OXFORDSHIRE COUNTY COUNCIL'S RESPONSE TO CONSULTATION ON THE FOLLOWING DEVELOPMENT PROPOSAL

Application no: 22/01682/F

Proposal: Development of a ground mounted solar farm incorporating the installation of solar PV panels, associated infrastructure and access, as well as landscape planting and designated ecological enhancement areas.

Location: Land North Of Manor Farm, Noke

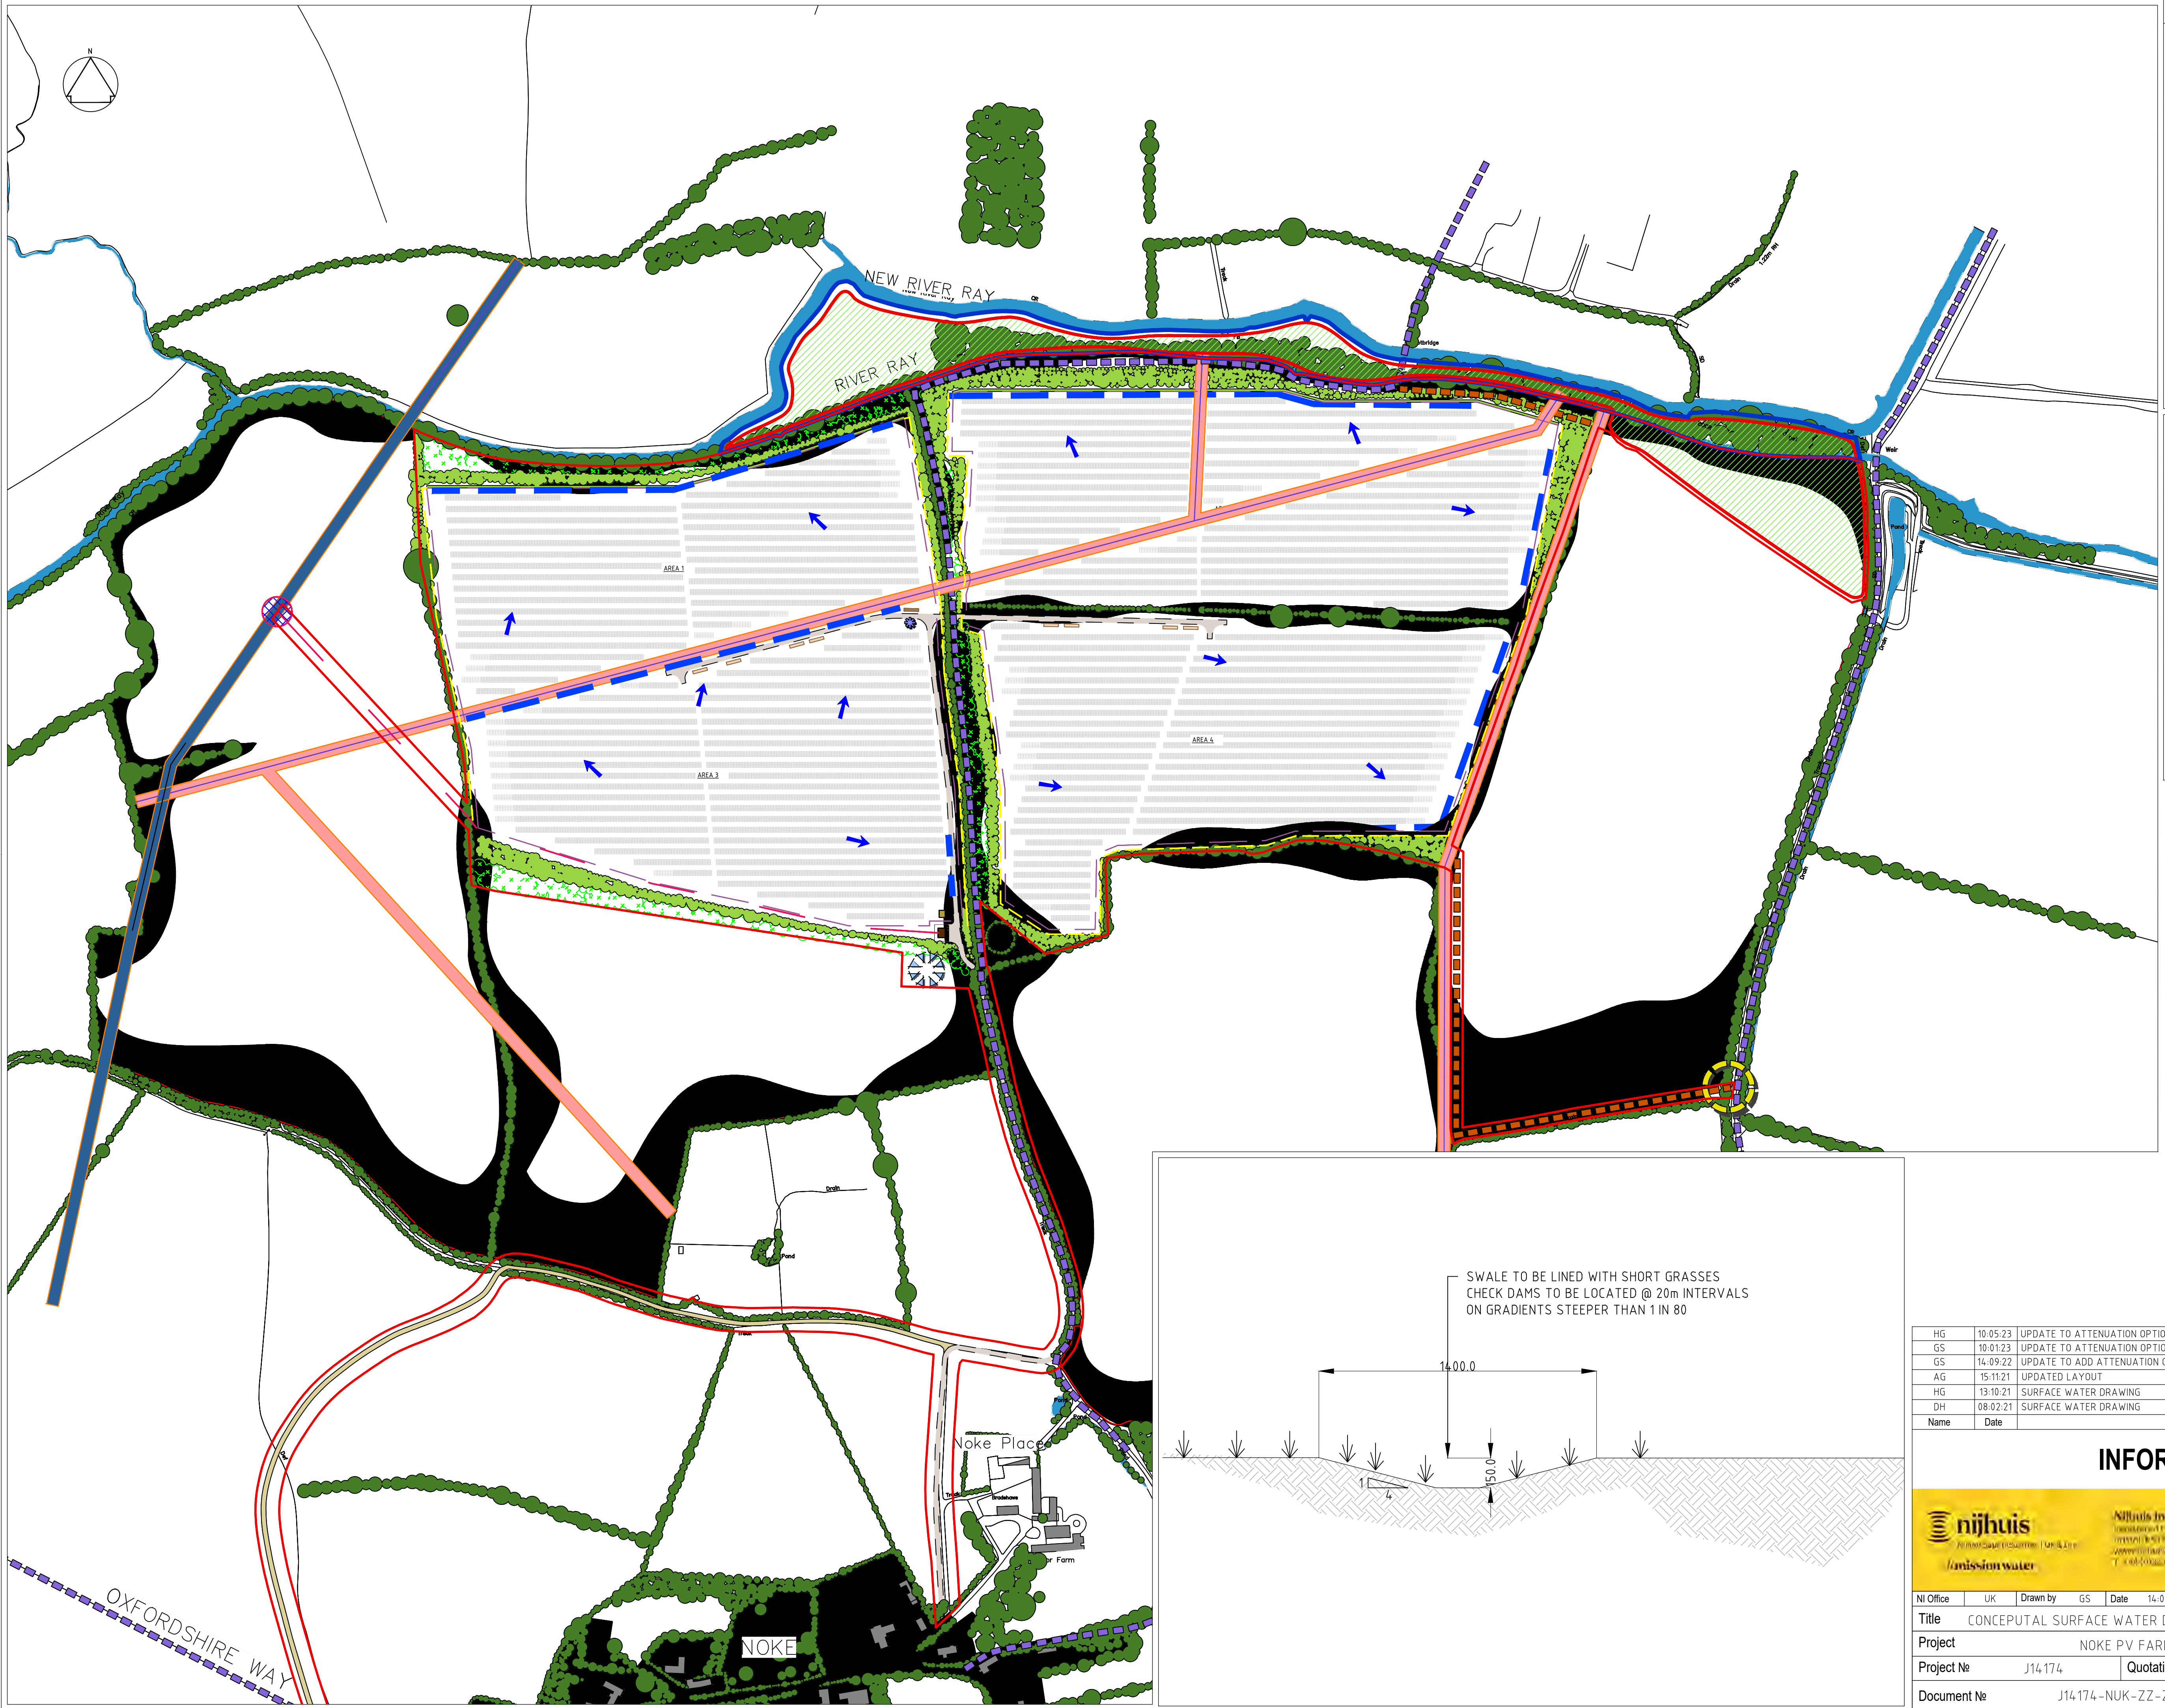
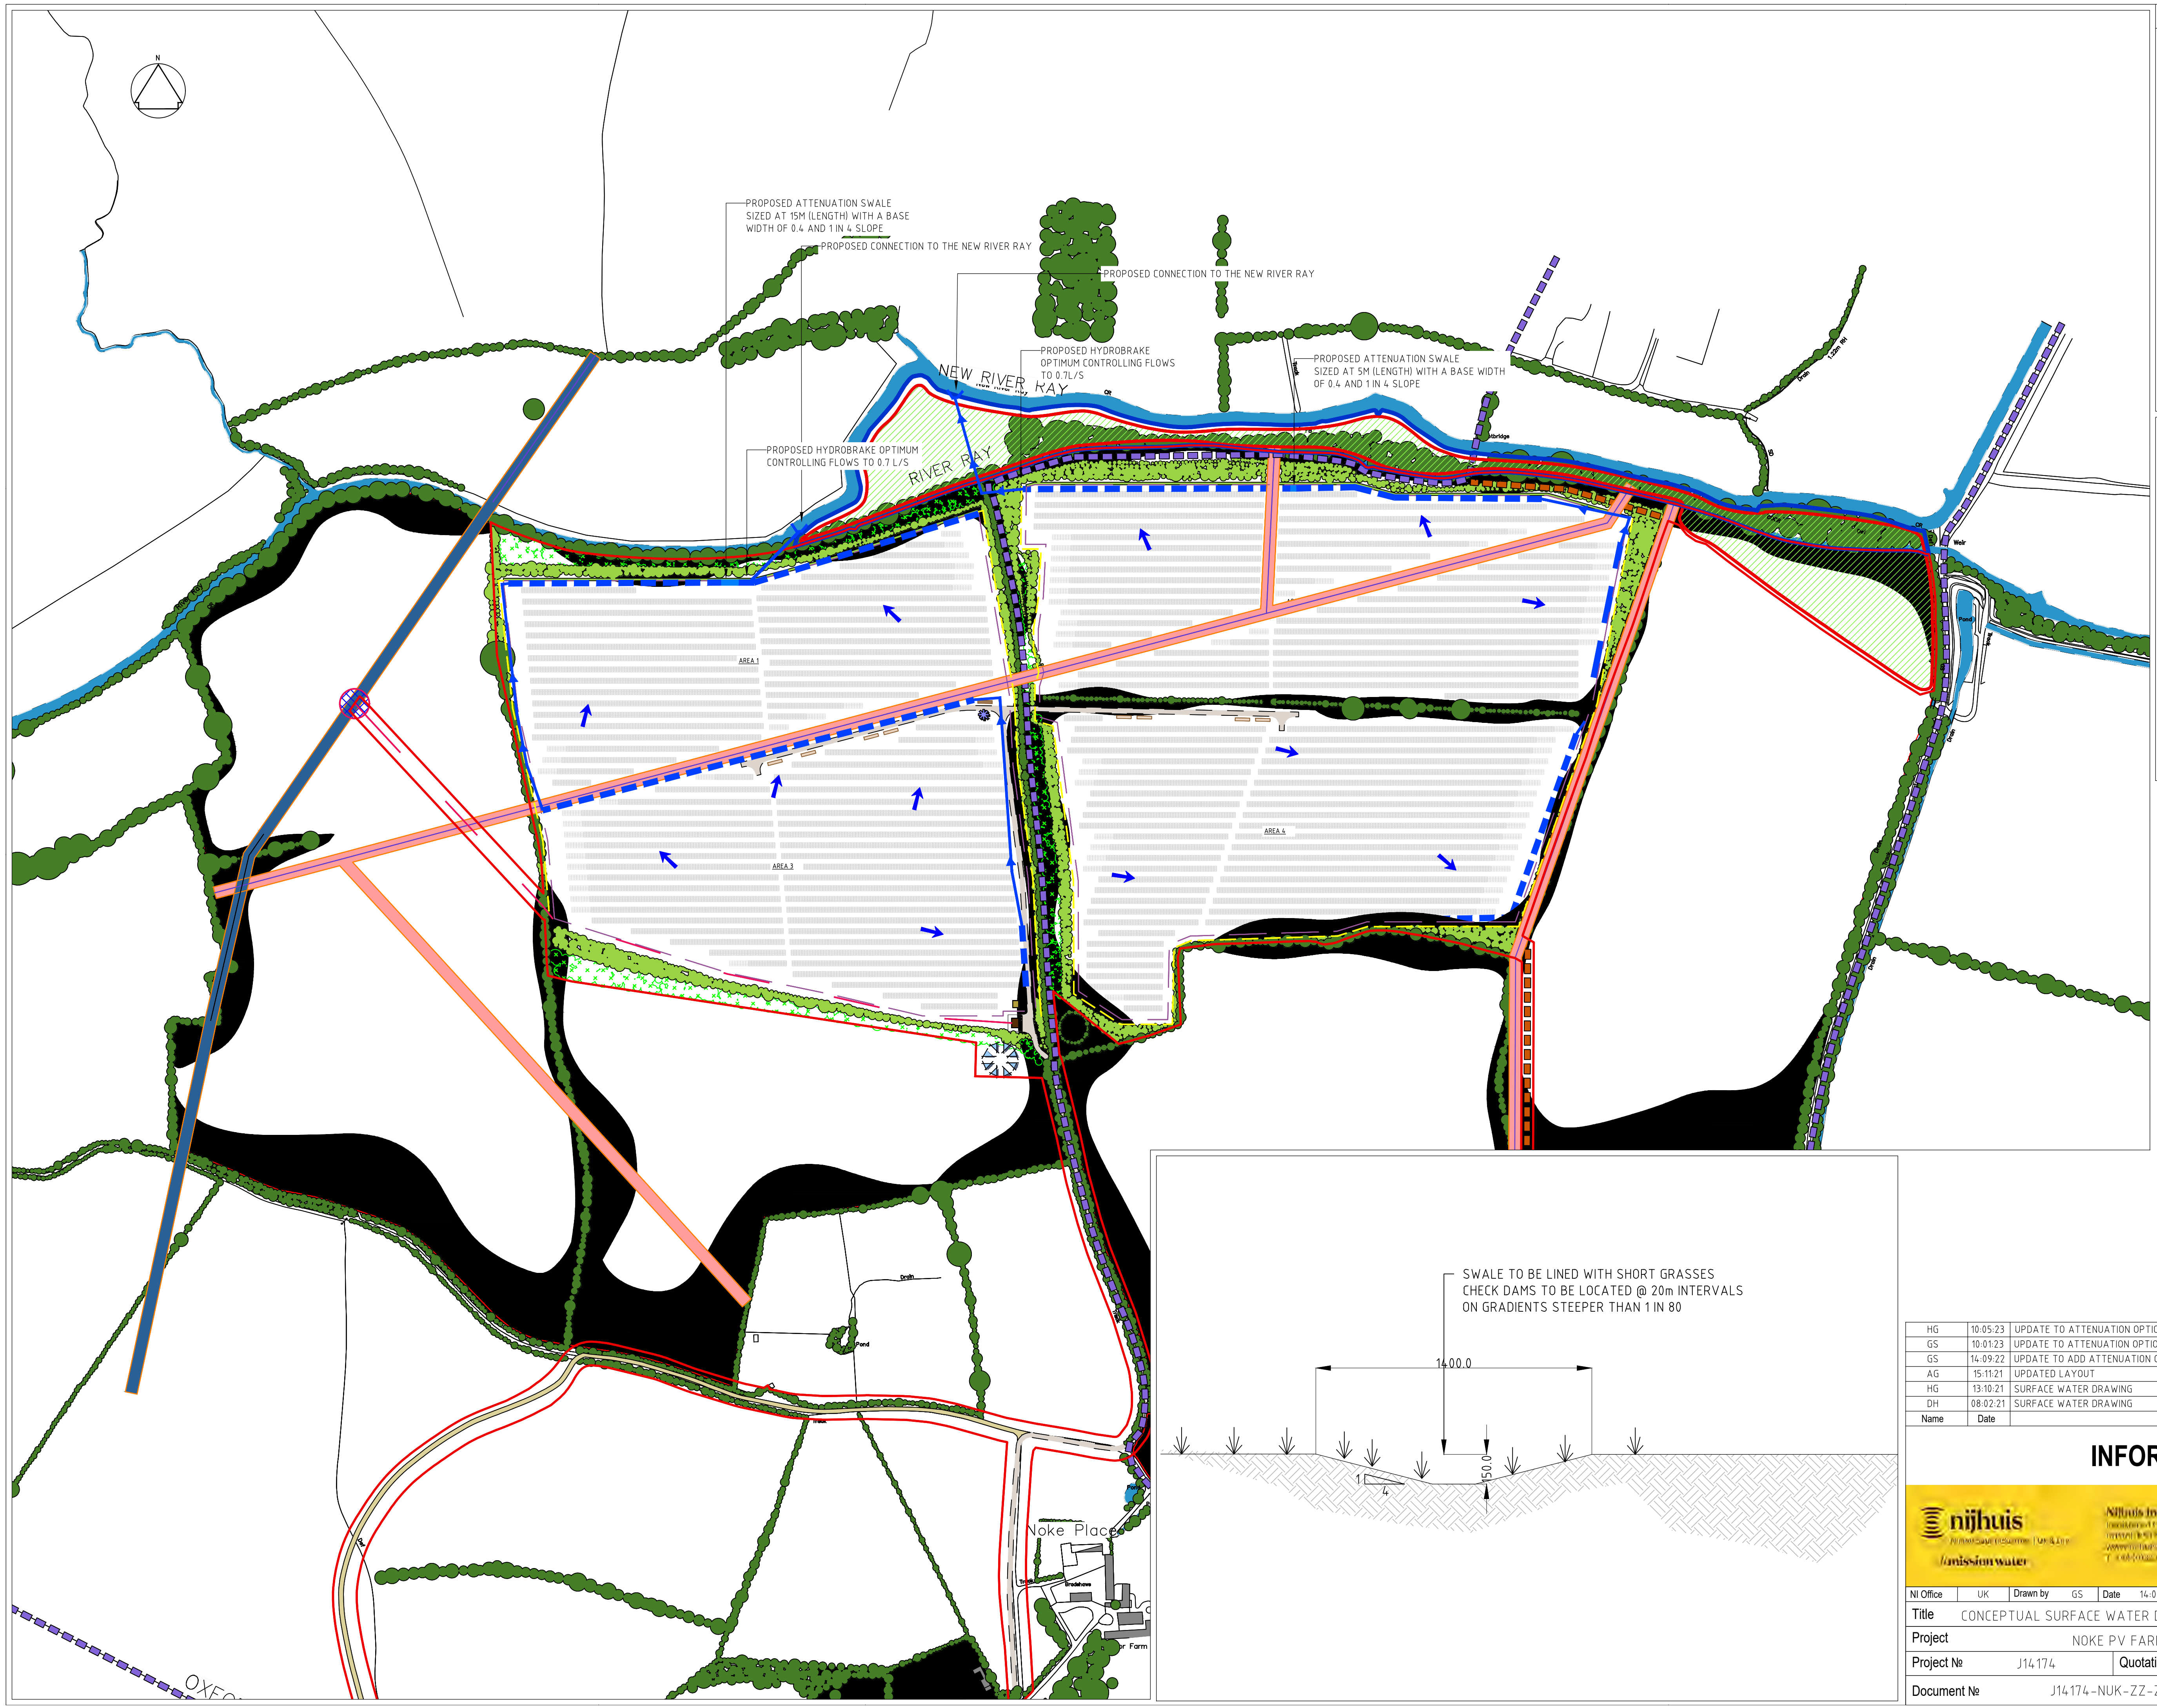
Discharge rates to be based on Qbar greenfield run off rate.

Provide updated drainage strategy drawing showing all the discharge rates based on Qbar greenfield run off rate.
